Application No: K/15/21/DOC
Site Address: Spring Tide Gorse Avenue East Preston BN16 1SF
Description of works: Approval of details reserved by condition imposed under ref K/40/18/PL relating to Condition No 5 - schedule of materials & finishes.

Thank you for your internet representation made on 23rd April 2021 which has been recorded as an objection with the comments as follows:

Drawing: DOC - Materials
ST - OBA - 00 - ZZ - DR - A - 0450 -
Status: Discharge Of Conditions OBA proj no: 247

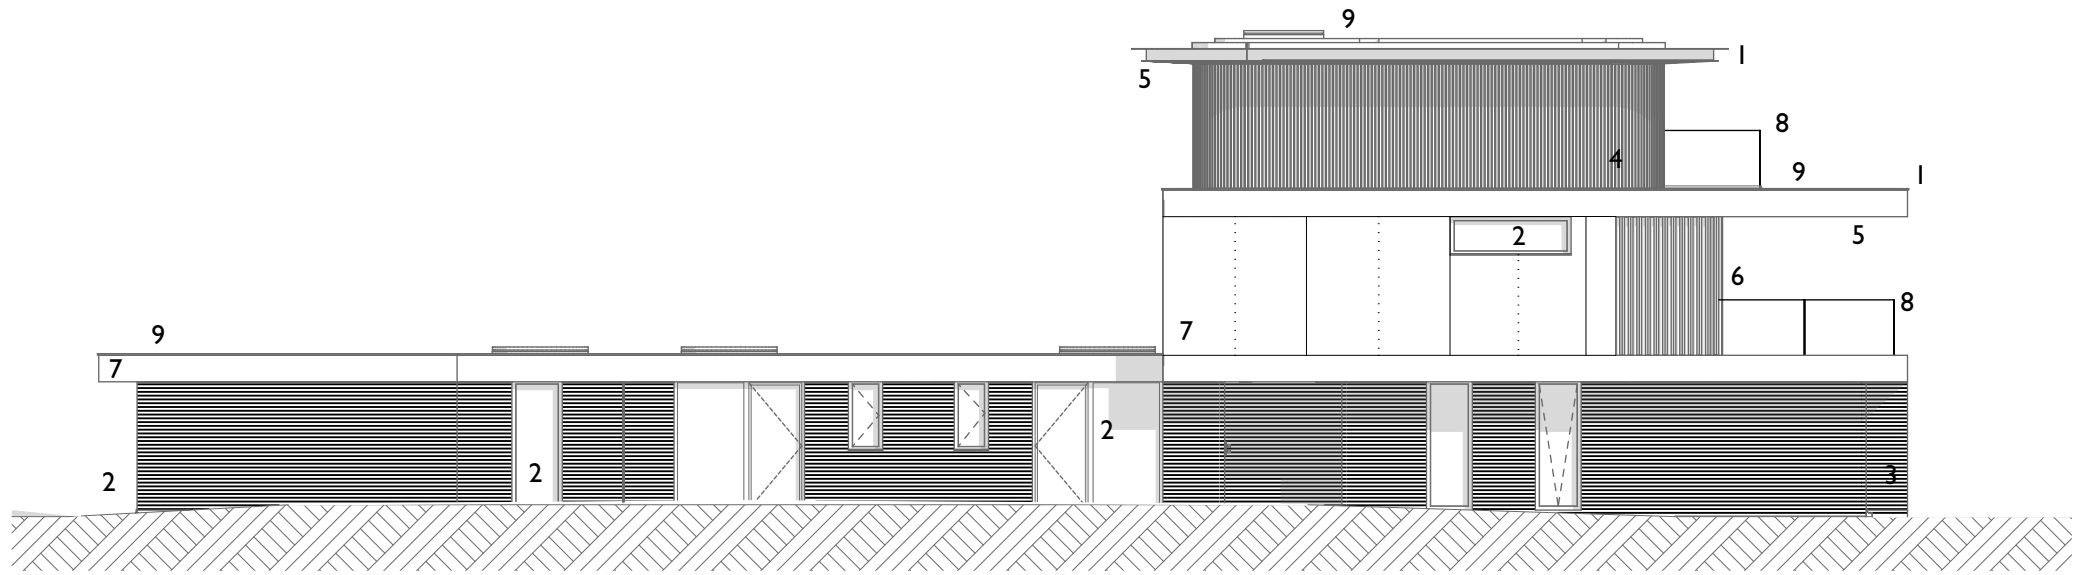
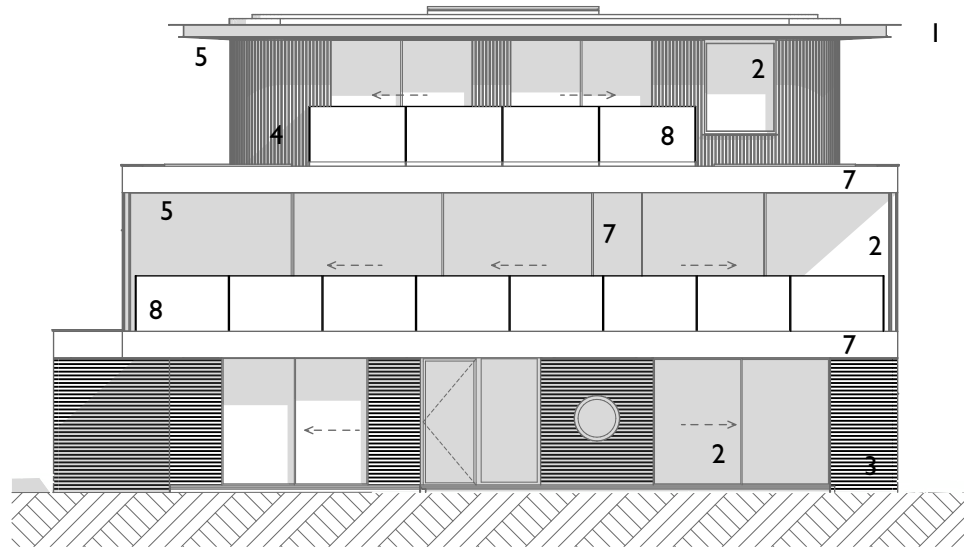
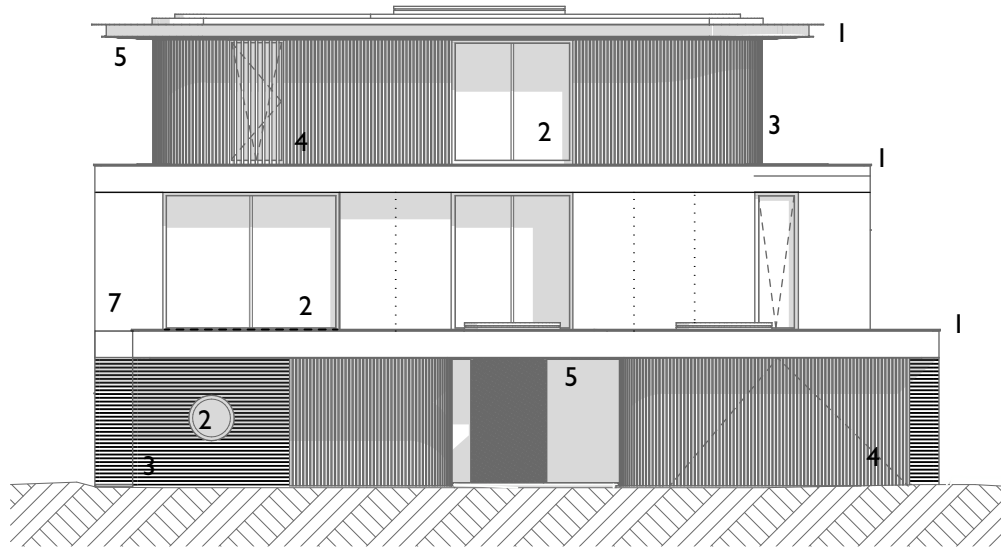
Council is concerned that clear glass is shown for balconies without privacy screening contrary to condition 3 of the decision re planning application K/40/18/PL that reads 'The side elevations of the balconies shall at all times be obscured to a height of 1.7m in accordance with details to be submitted to and approved by the Local Planning Authority and the screening shall be retained as agreed in perpetuity'
